Your ref: SSD-66876472
Our ref: DOC25/947421

Request for advice on the Environmental Impact Statement (EIS) for Berrima Gaol site, 2-4 Argyle Street and 30 Wingecarribee Road, Berrima, NSW, 2577. SSD – 66876472

Attachment A: CPHR Detailed Comments on the Berrima Gaol site Environmental Impact Statement

Figure 15: T93 and T94 located on Wingecarribee Street (Nadin, 2024).

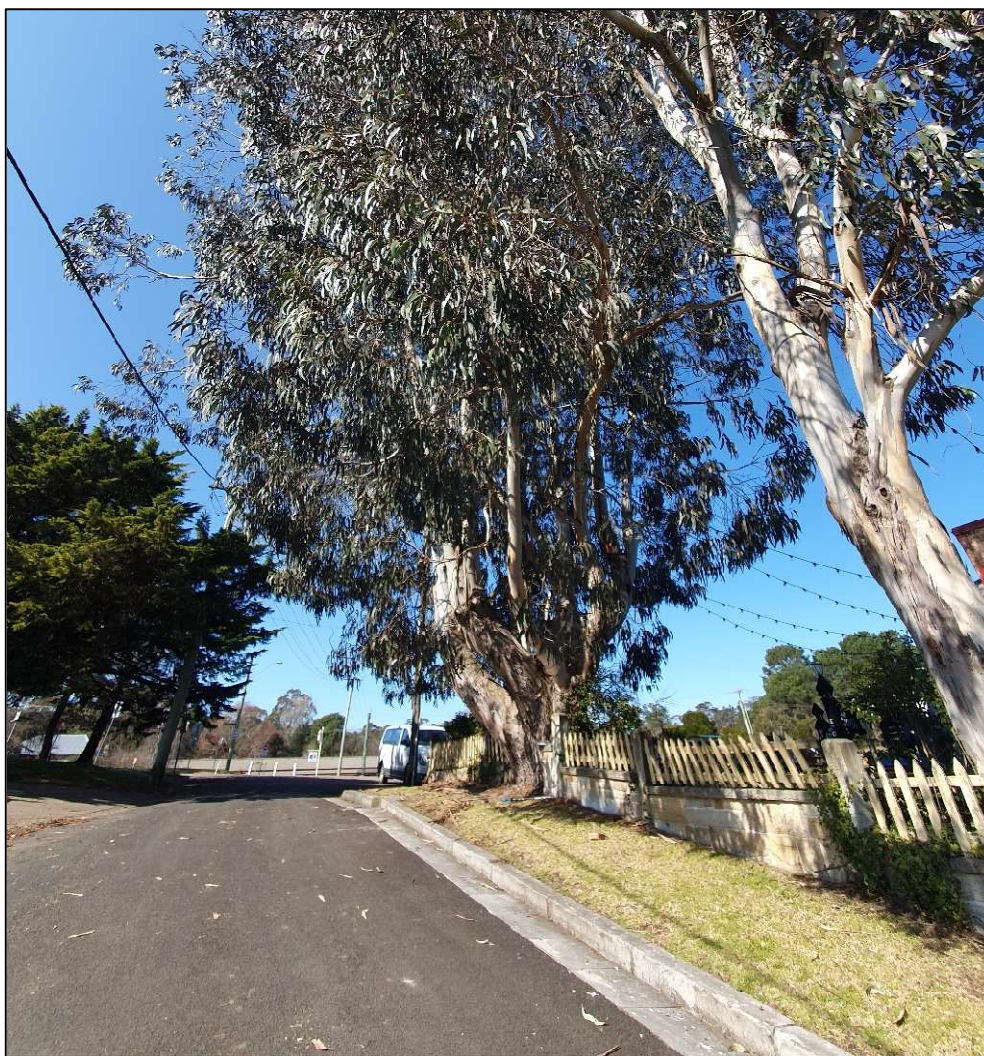
- Trees 93 and 94, both identified as Southern Blue Gum *Eucalyptus globulus bicostata* will be retained and protected, however has been assessed in the AIA as likely to incur a 'major' impact. These trees will be impacted by the proposed Wingecarribee Street upgrade. The trees are currently located adjacent to the existing curb and gutter of the road. However, to ensure that no further encroachment into the NRZ of these trees occurs, the applicant must:

- Ensure that the existing curb and gutter remain in situ, and
 - No excavation deeper than that of the current road profile occurs, and
 - All works undertaken within the Notional Root Zones (NRZ), if required, will be directly supervised by a project arborist.
